Dwg No. E25/8281/001
 Date: DEC 25
 Scale: 1/500 @A1

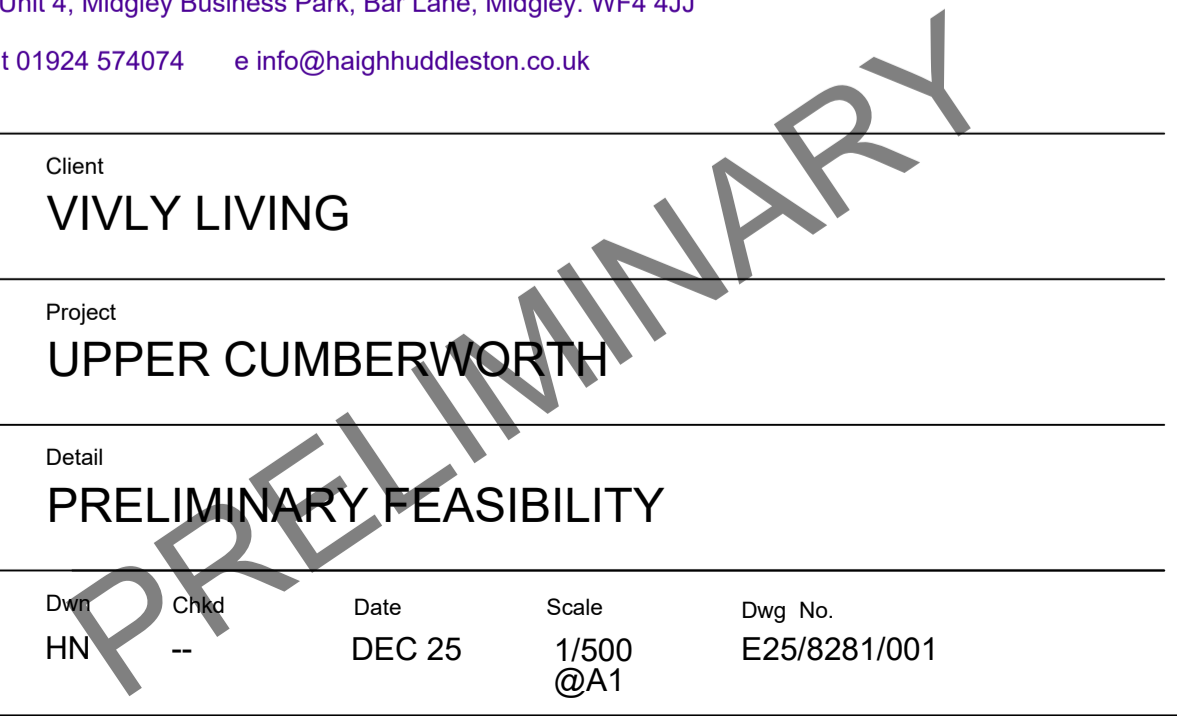
The current arrangement of a sewage pumping station and attenuation of surface water is inadequate. The sewage pumping station will fail. This is not speculation. There are two pumps and at some point they will both fail. 100%. When they do the pumping station will over top. As it doesn't appear to have any storm storage I'd be keen to understand what the mitigation is to prevent a pollution incident in the ANCIENT WOODLAND.
